**From:** Carmichael Ian <Ian.Carmichael@thamesvalley.pnn.police.uk>  
**Sent:** Thursday, January 16, 2020 3:18 PM  
**To:** Matthew Chadwick <Matthew.Chadwick@Cherwell-DC.gov.uk>  
**Cc:** Planning <Planning@Cherwell-DC.gov.uk>  
**Subject:** Planning Ref: 19/02796/F. Recreation Ground, MUGA and Pavilion. OS Parcels 3309 and 4319 Adjoining and North of Milton Rd Adderbury.

**Planning Ref: 19/02796/F. Recreation Ground, MUGA and Pavilion. OS Parcels 3309 and 4319 Adjoining and North of Milton Rd Adderbury.**

1 North Elevation
1 : 100

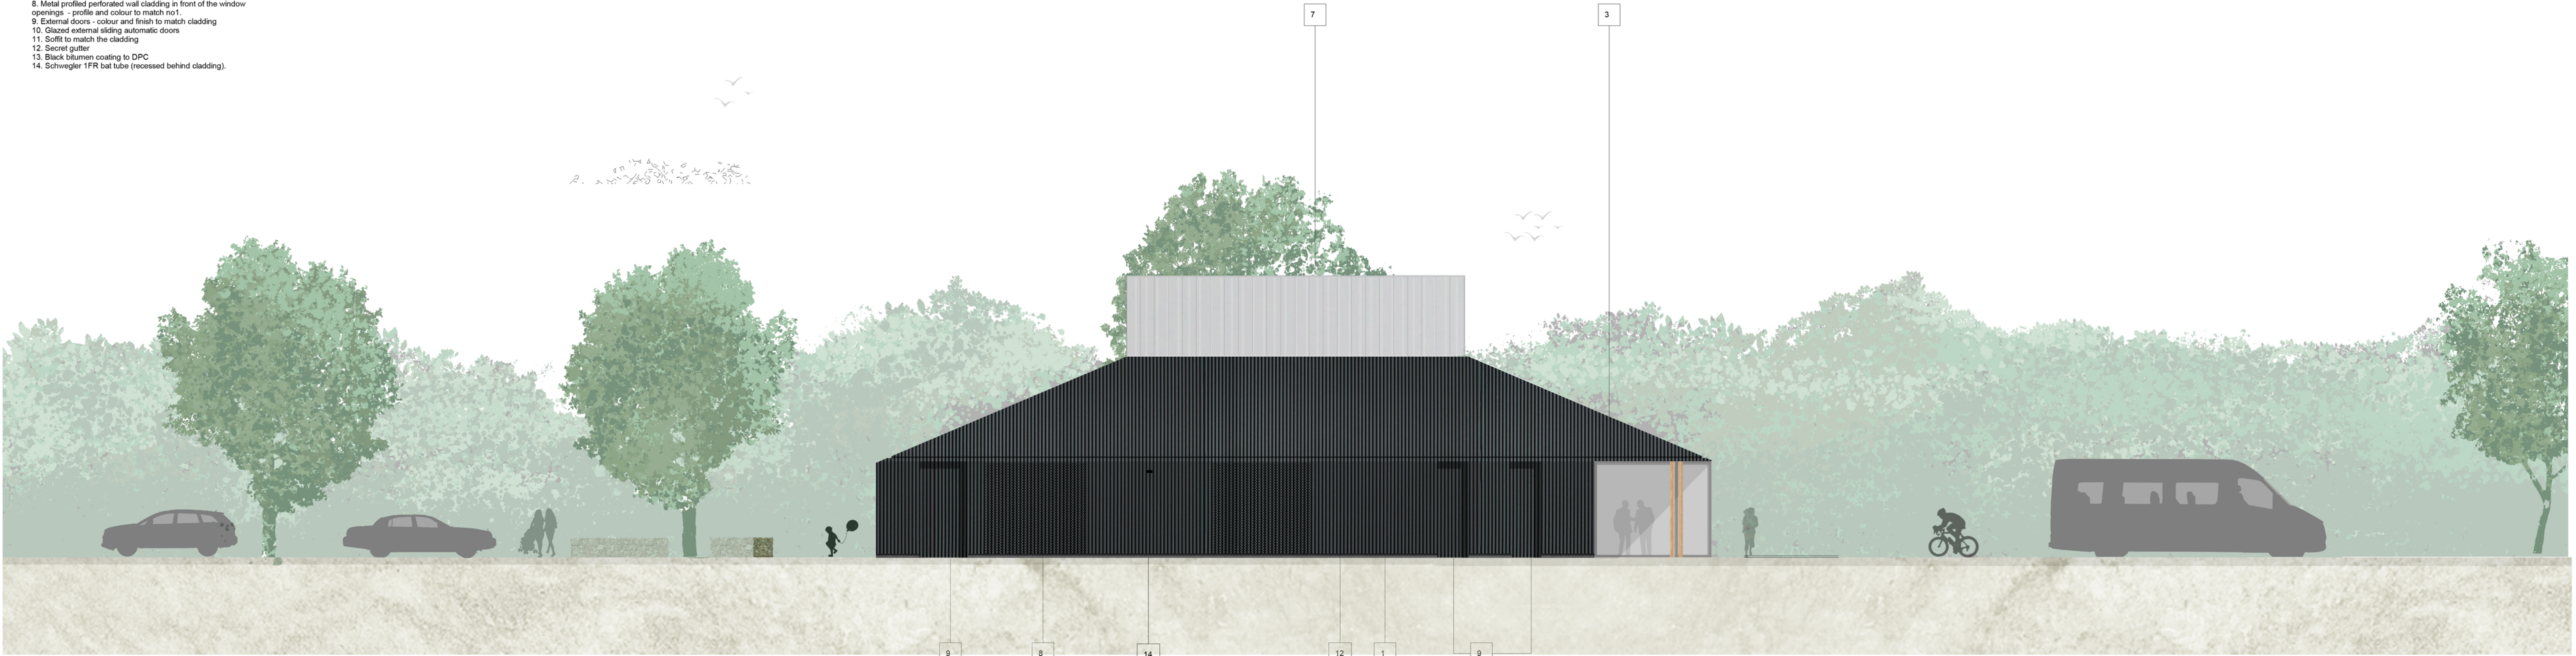
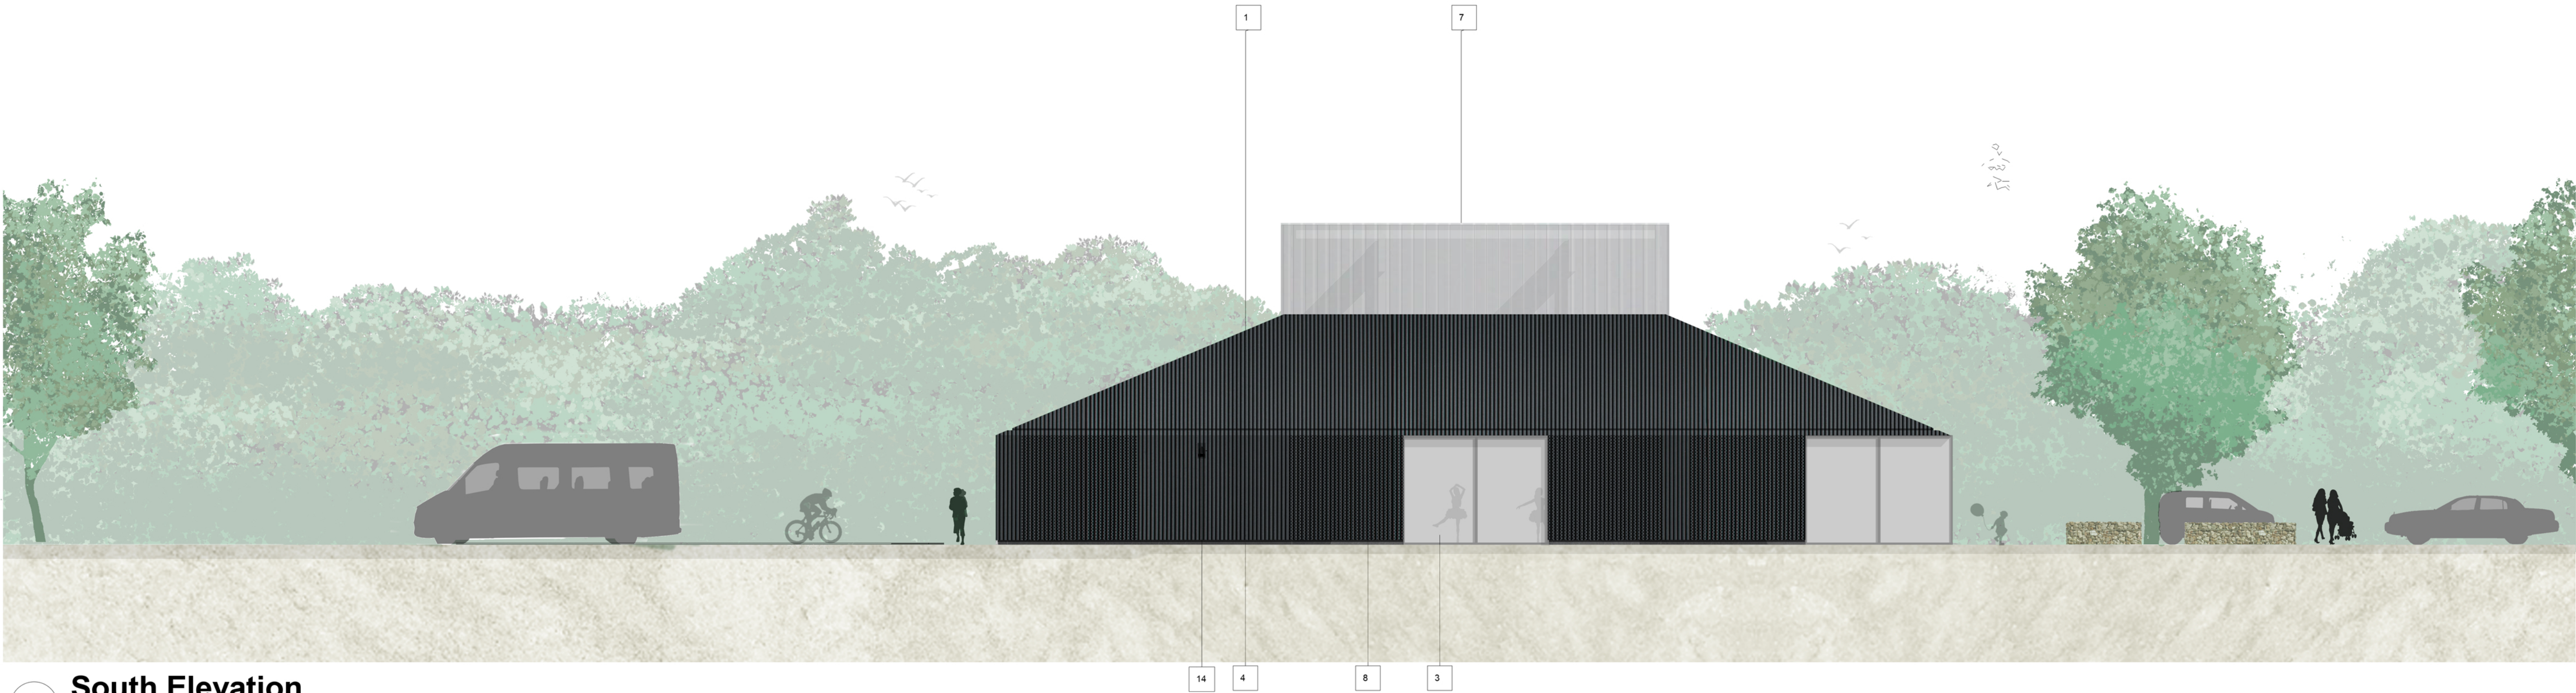
- The recessed entrance to the pavilion and the covered external terrace concern me as such areas are often used as impromptu youth shelters and can attract ASB as well as conceal other criminal activity. I recommend these covered areas are designed out. In addition, I suggest that a secondary set of doors is provided internally at the main entrance so that access can be controlled by users of the facility that may be more vulnerable, or are made so by the remote location of the premises or the time of day.
